Intake Comments

**Permit #2211-123, Hatley Residence**

See below in response to review comments dated November 23, 2022.

1 FOUNDATION (WALLS & HARDWARE)
SCALE: 1/8" = 1'-0"

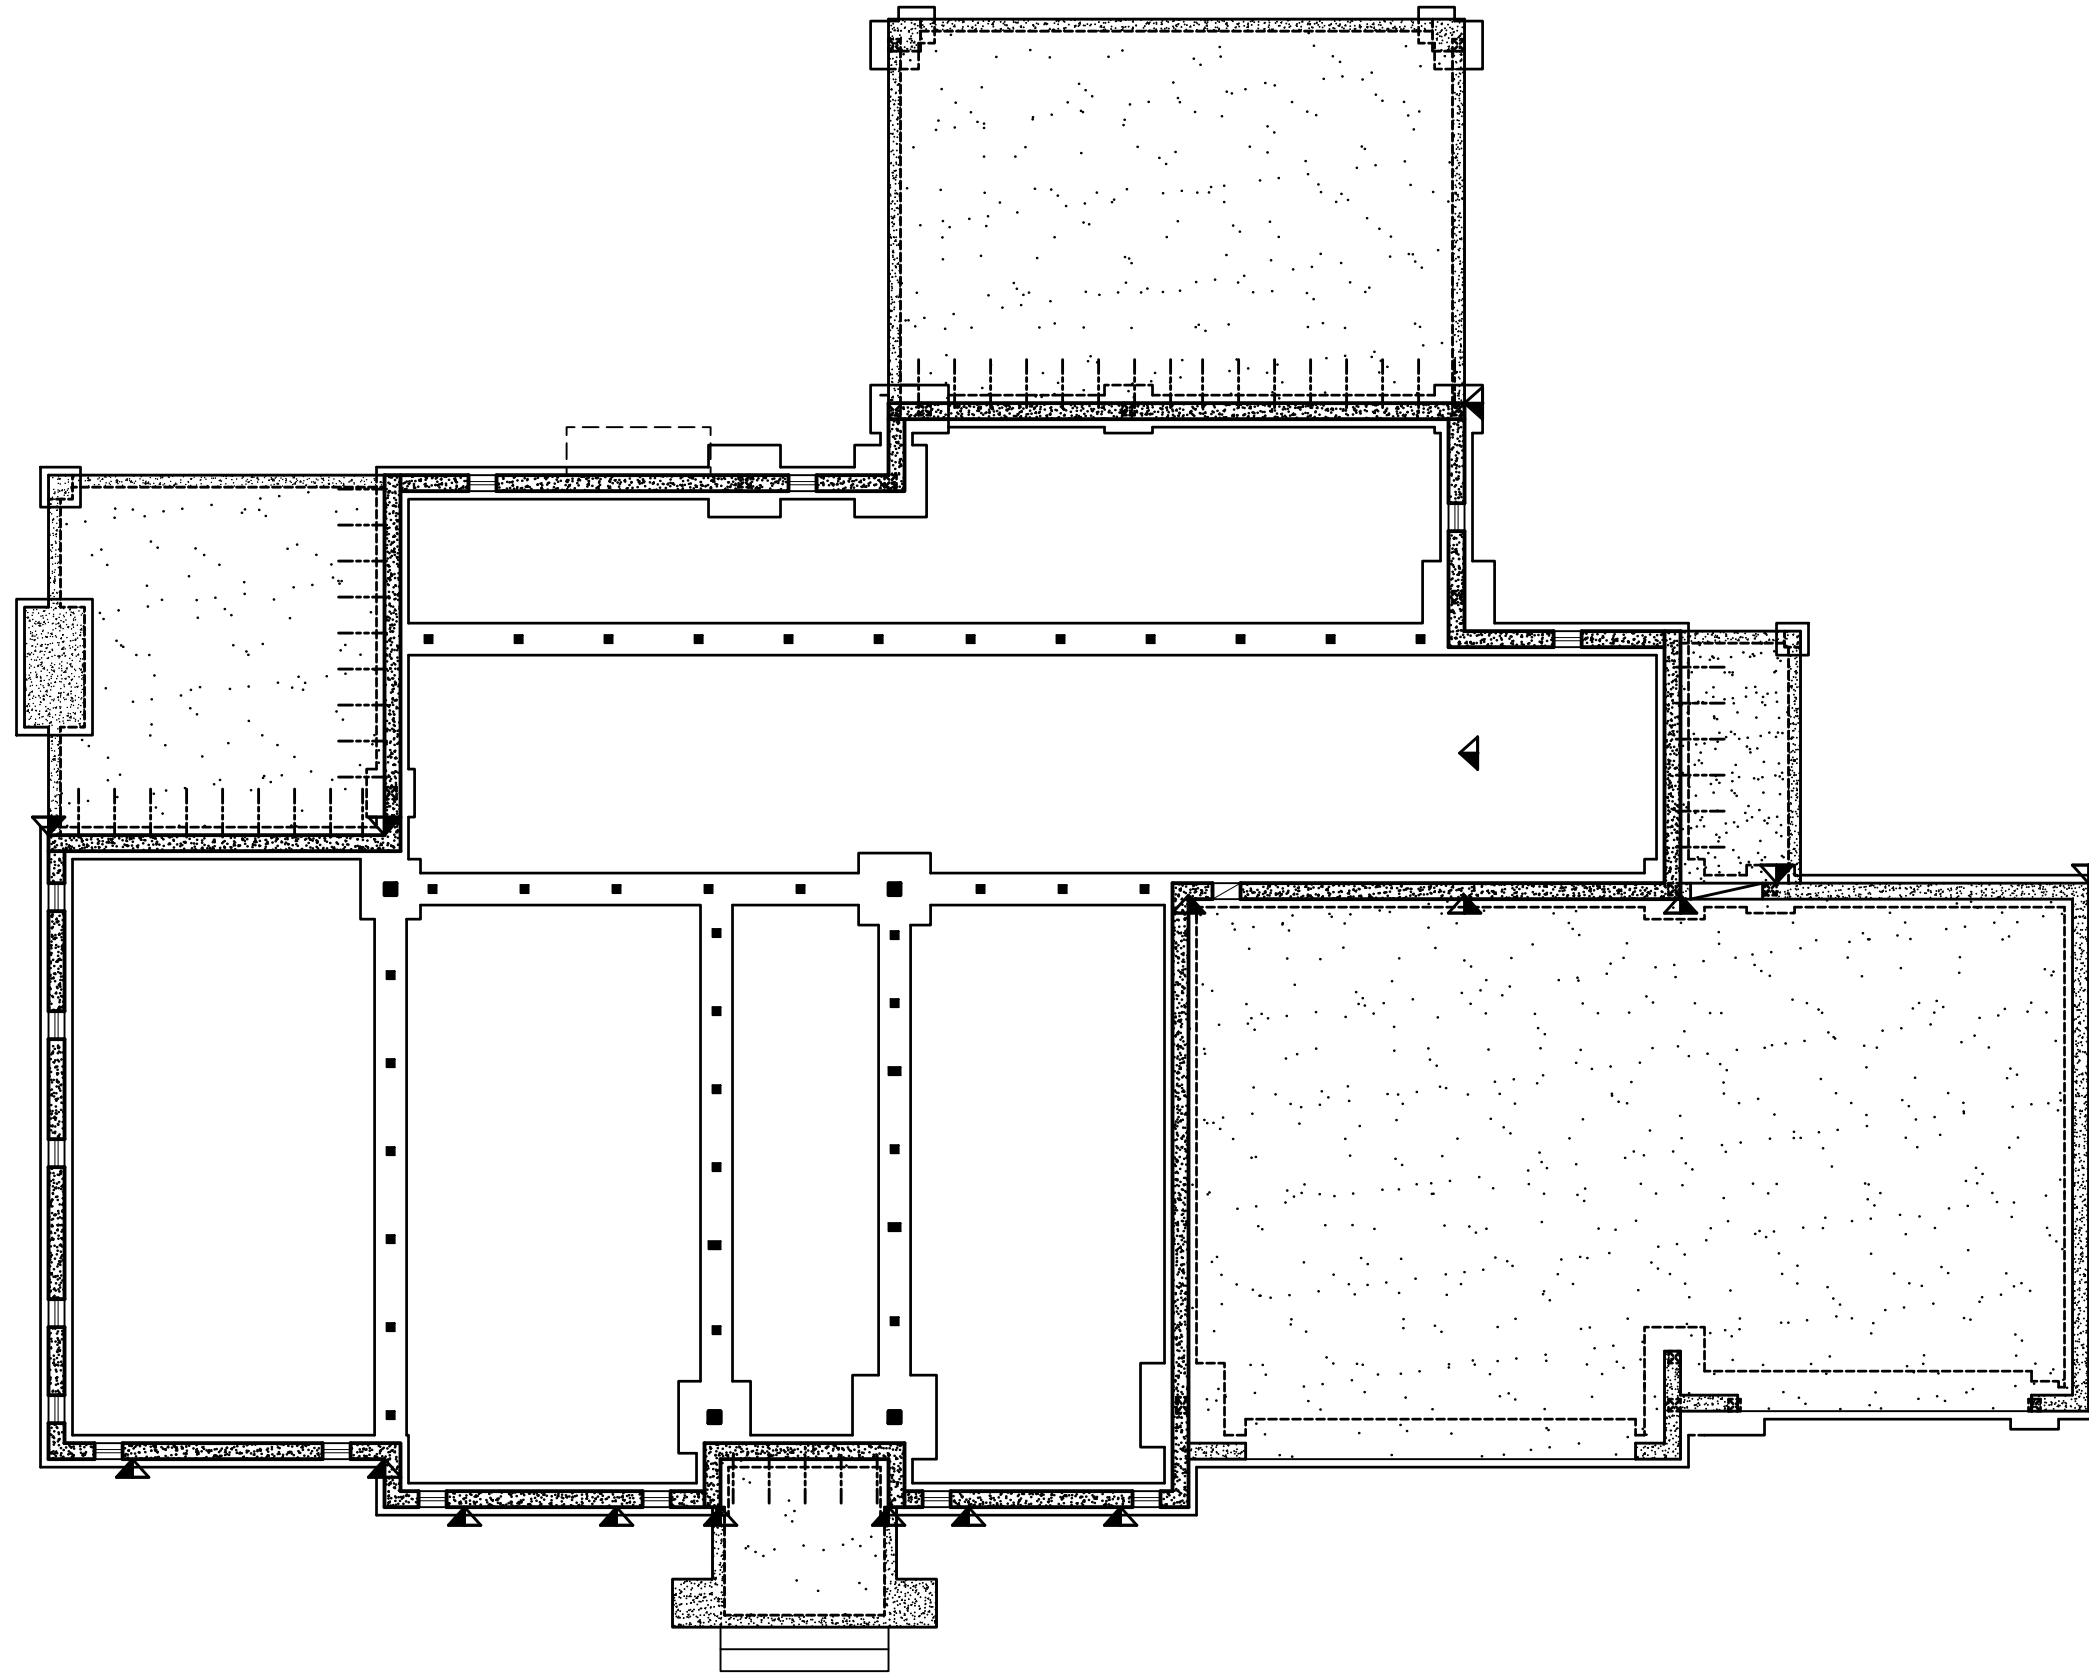
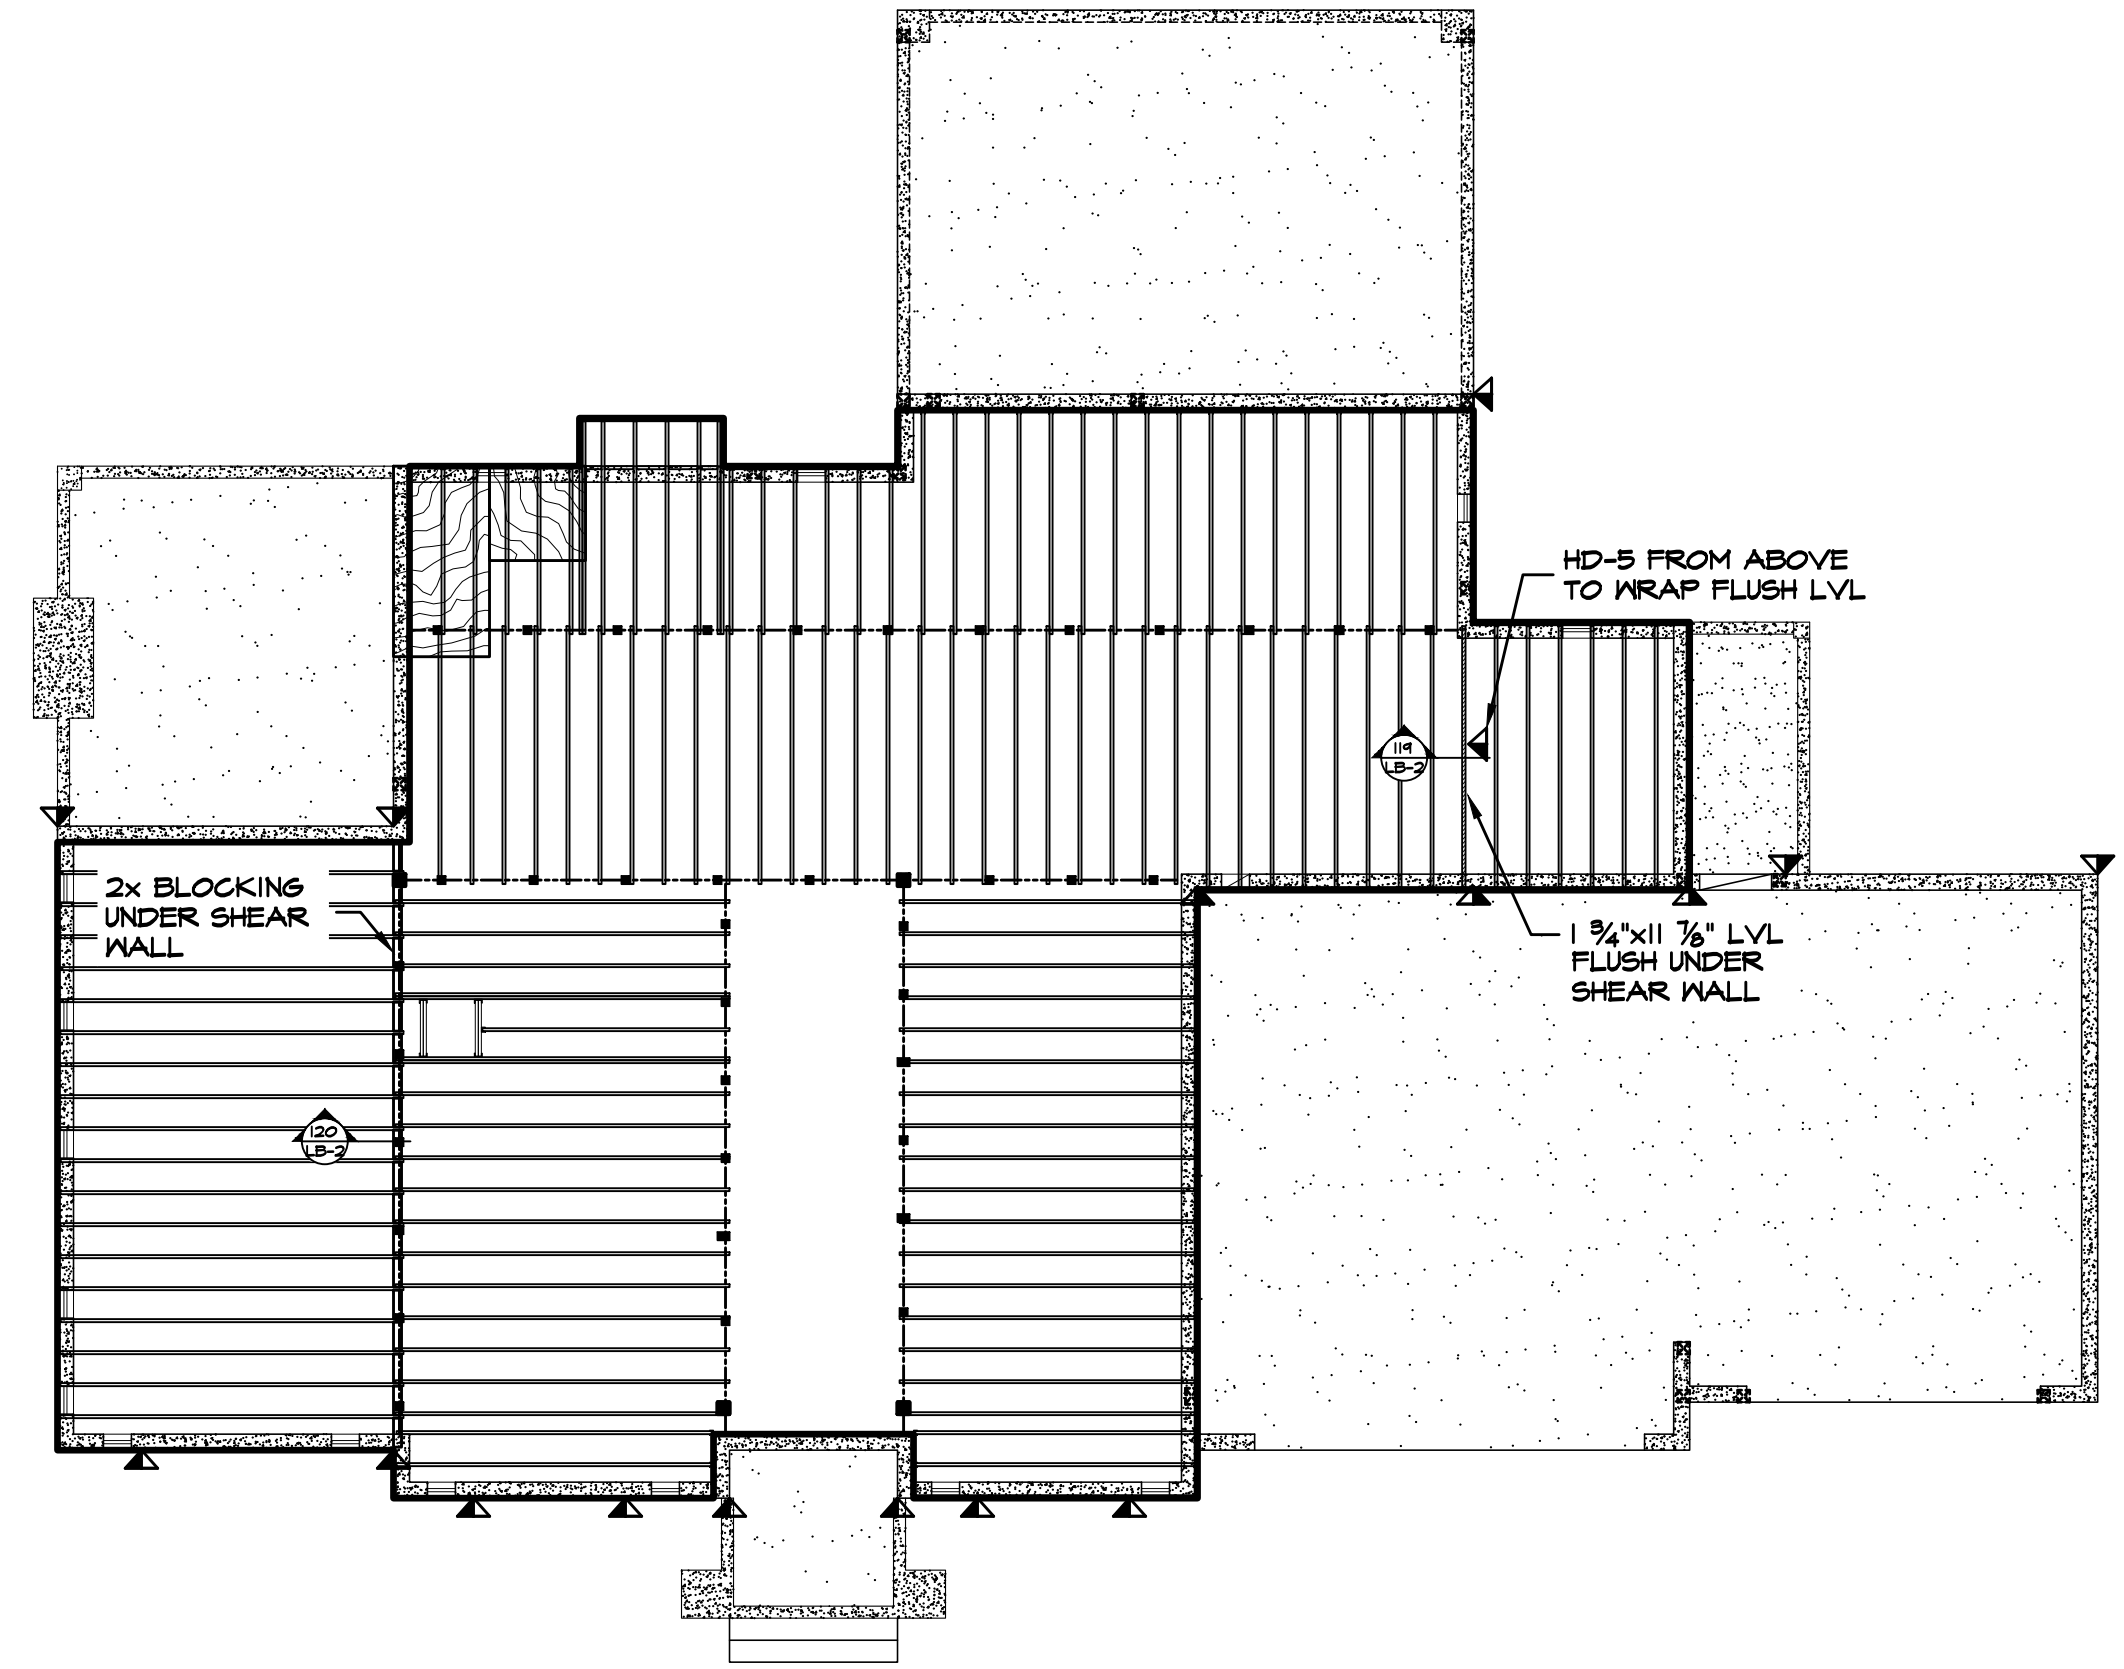
1. The lateral calculations by Mulhern + Kulp were previously provided to the client, but may have been omitted from the submittal. The seismic design criteria is shown on sheet S-0.0, and was derived from the attached ASCE hazard report.
2. Key plans for the shear walls are provided on sheets 4 and 5 in the lateral calculation packet by Mulhern + Kulp. Key plans for the gravity framing are provided on the last pages of the gravity calculations.
